MEMORANDUM

TO: Jean Fraser, Planner
FROM: David Senus, P.E. & Ashley Auger, E.I.T.
DATE: July 25, 2012
RE: Jordan's Site Mixed Use Development, Level III Final Site Plan/Subdivision Application

Woodard & Curran has reviewed the response to comments on the Level III Final Site Plan/Subdivision Application for the Jordan's Site Mixed Use Development located at 203 Fore Street in Portland, Maine. The project consists of development of a five story mixed use condominium building with retail space, office space, and residential units.

**PLAZA GRADING AND DETAILS**

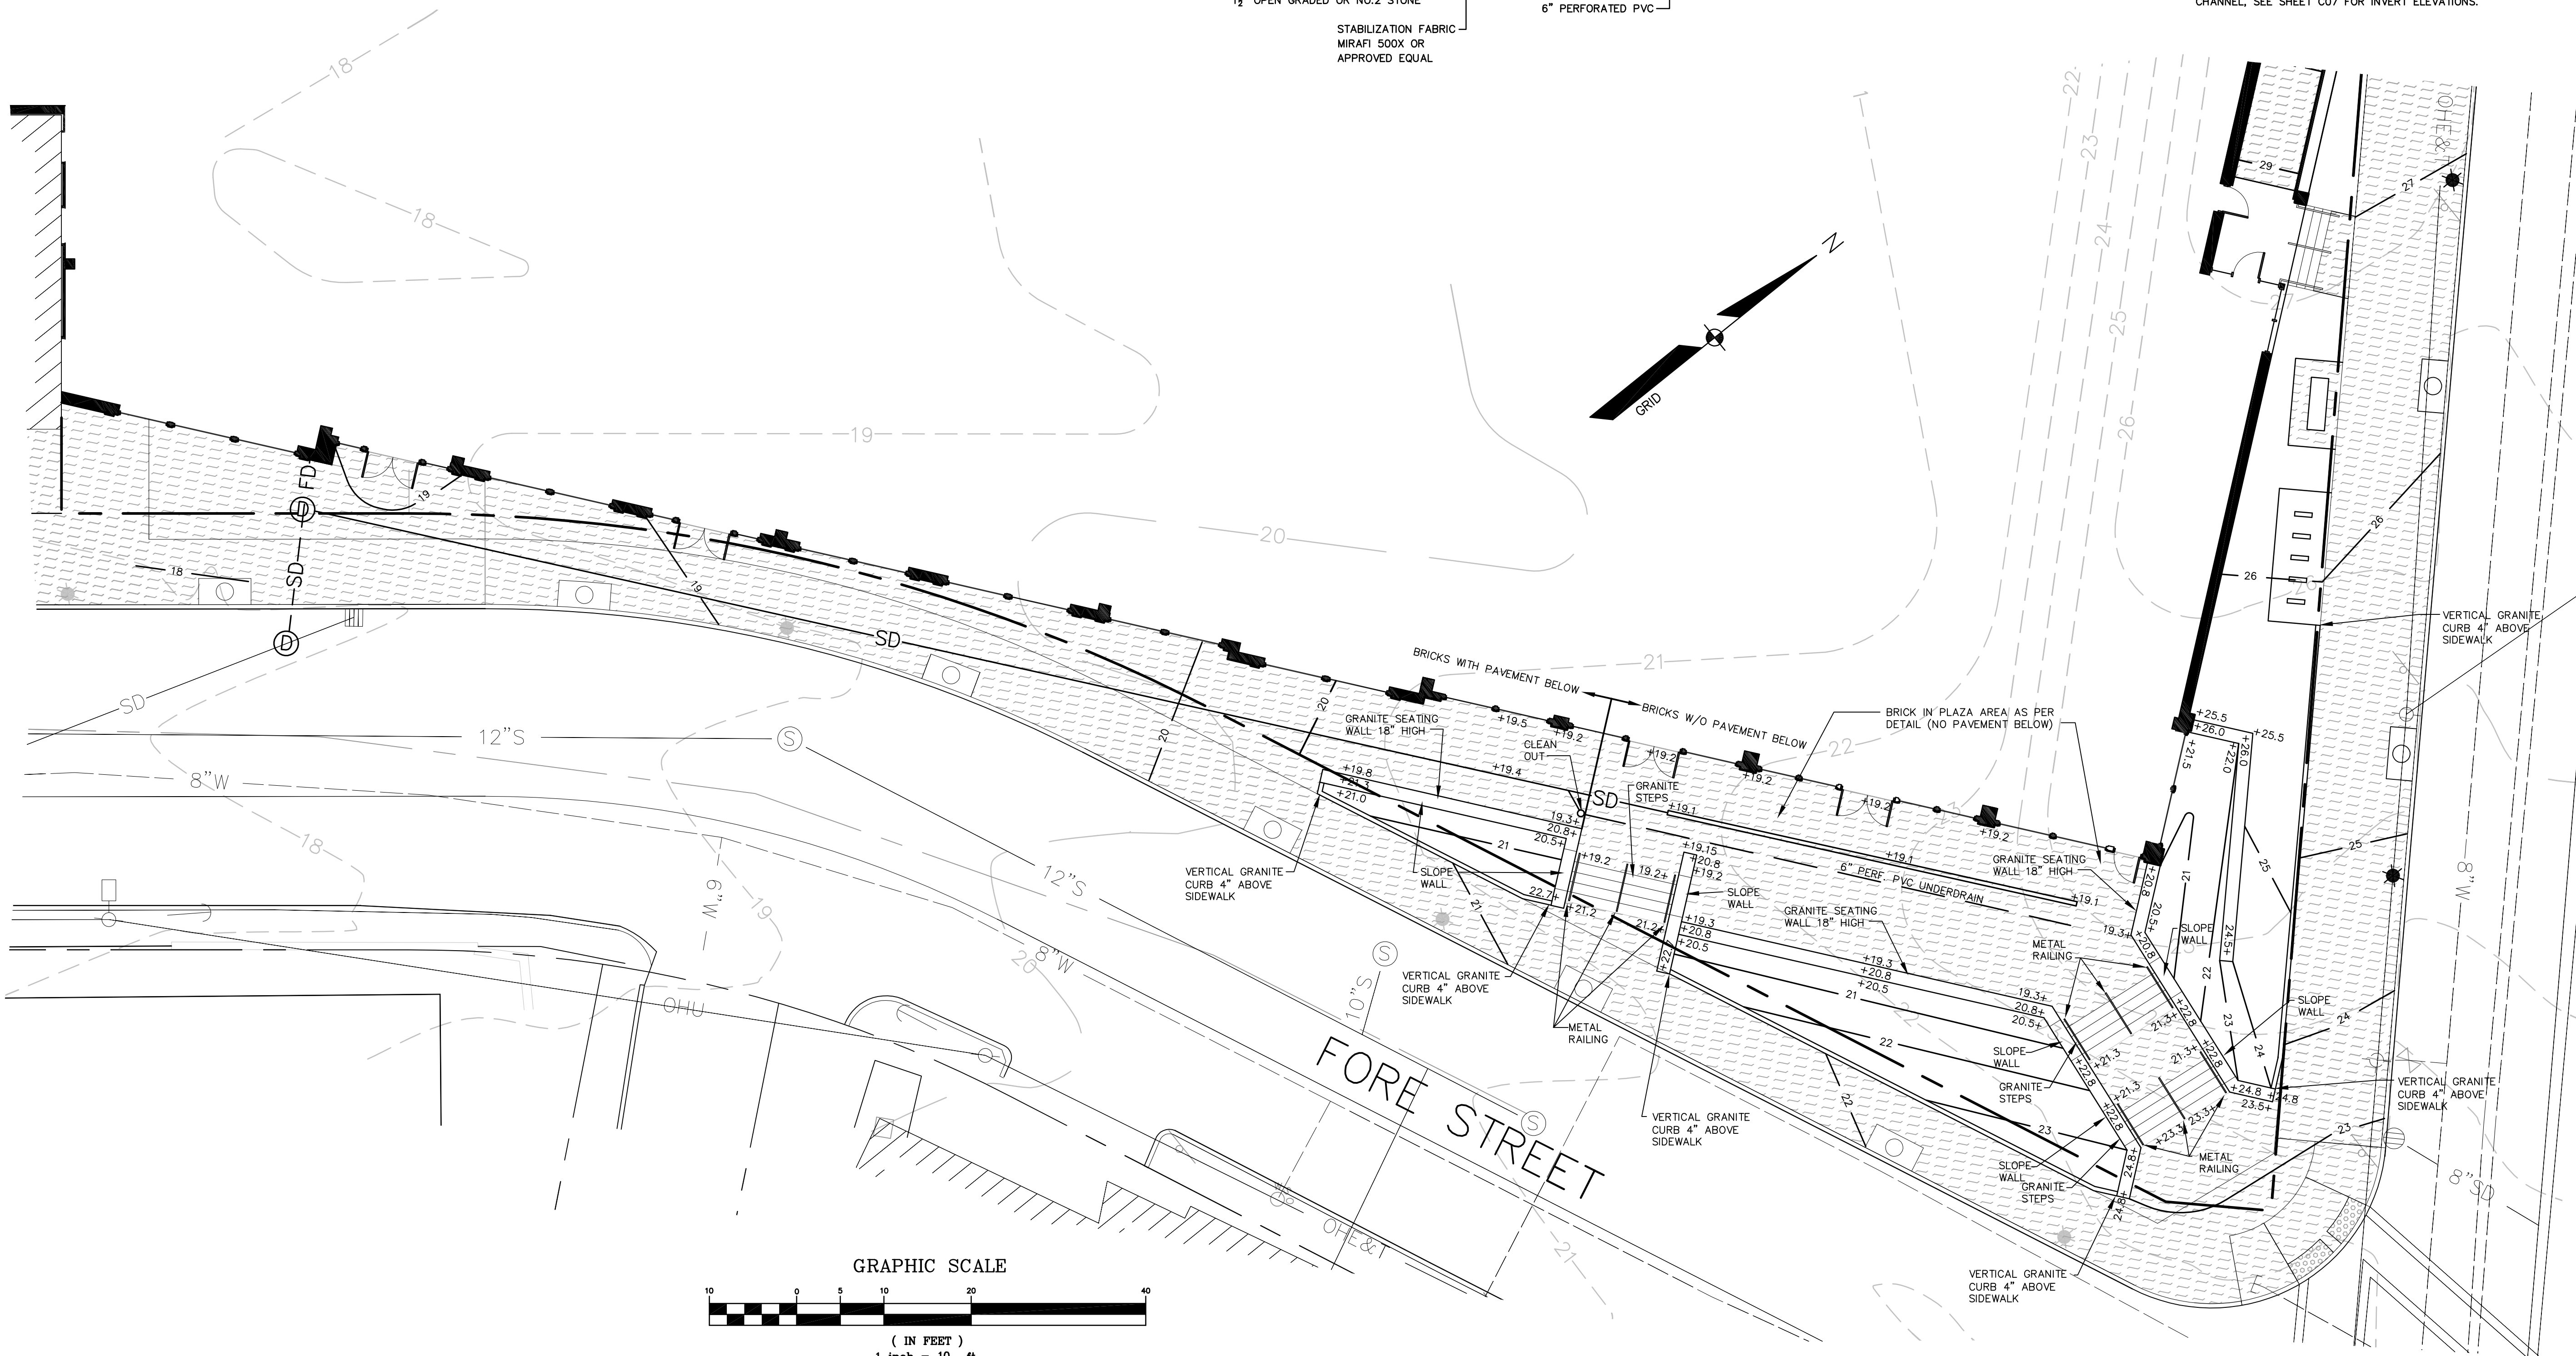
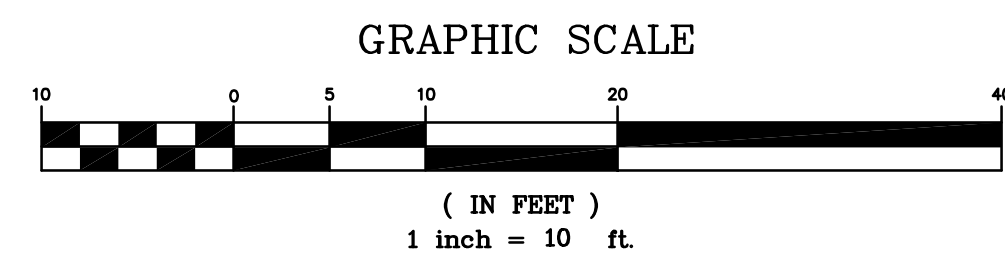
1. The detail of the pavement area treated by tree box filter adequately addresses the comment contained in the Woodard & Curran memorandum dated June 6, 2012.
